**WEST SUSSEX COUNTY COUNCIL
STRATEGIC PLANNING CONSULTATION**

SUBJECT: BN/43/16/PL - 95 No. dwellings together with access, landscaping open space & associated works.

LOCATION: Angels Nursery, Yapton Road, Barnham, West Sussex, PO22 0AY.

This is the WSCC highways and transport response to the above planning application. It follows submission and review of submitted information – notably drawings 15081/001, 15083/TK01 and 15083/SK02 and Transport Statements - produced by the applicant's Transport Consultant, Milestone Transport Planning.

GENERAL ARRANGEMENT

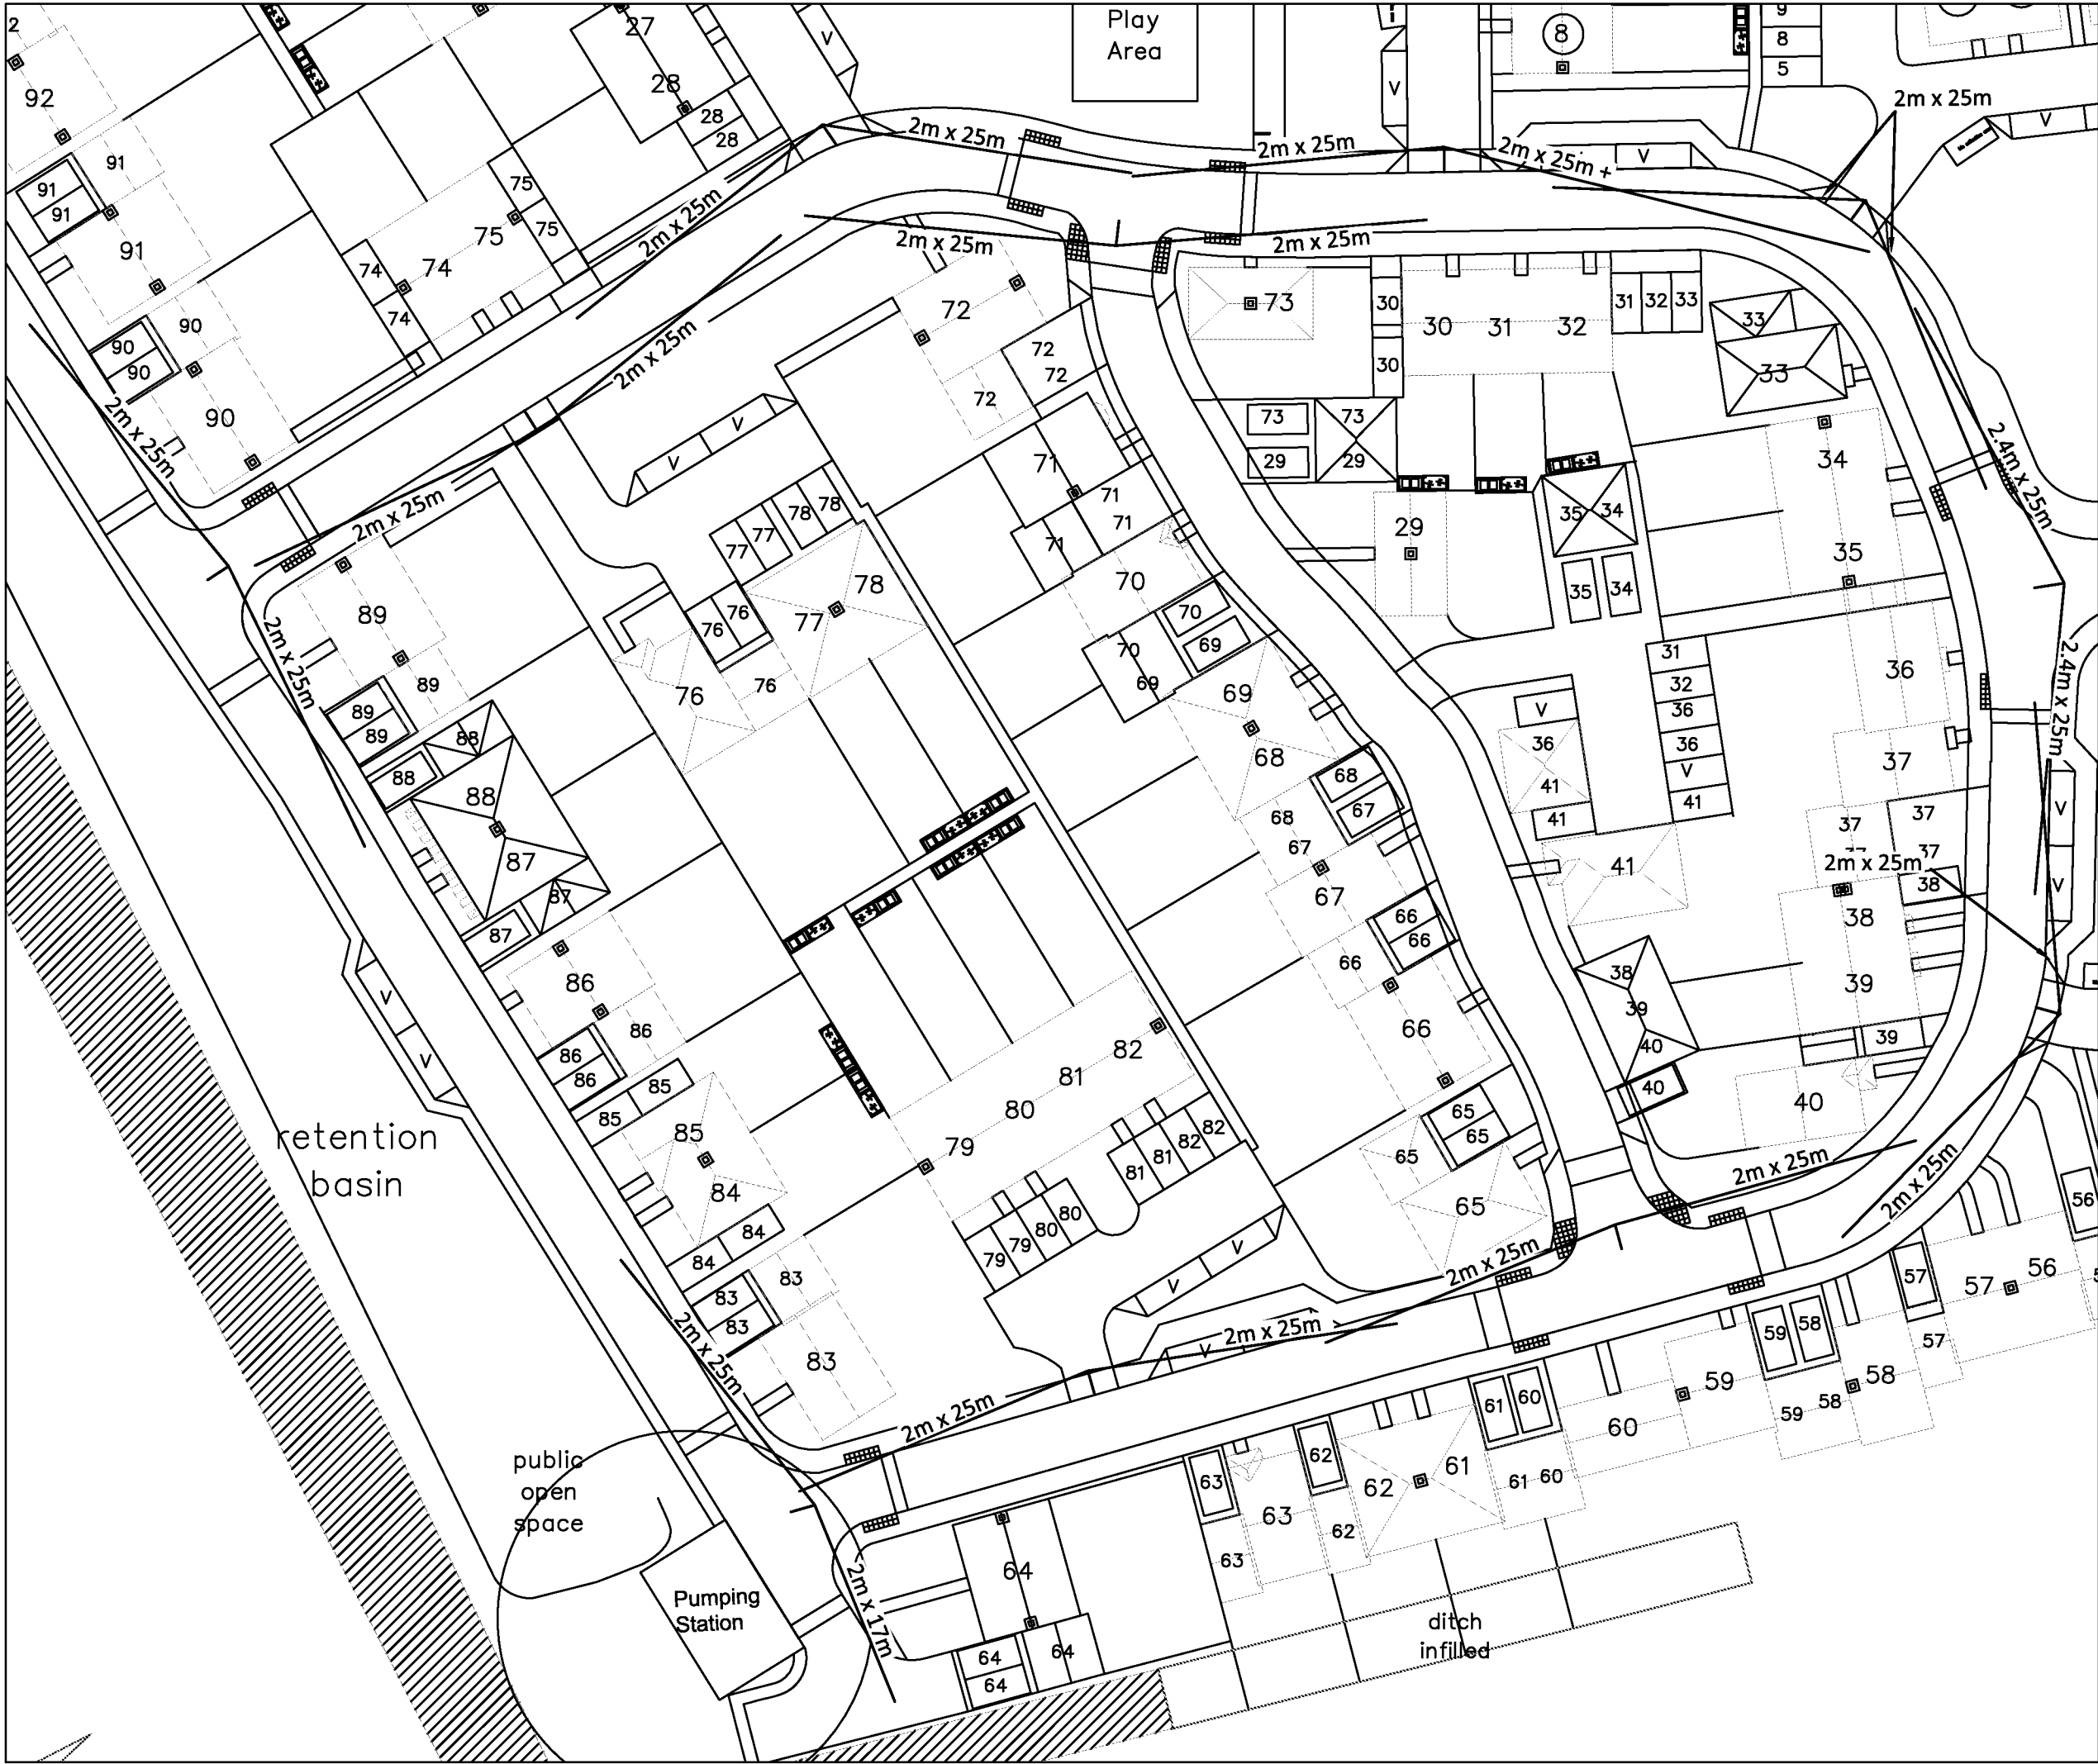
attention should be paid at the S38 stage to ensuring adequate margins around the turning heads adjacent to plots 64 and 95. Currently, these are not fully shown in these locations.
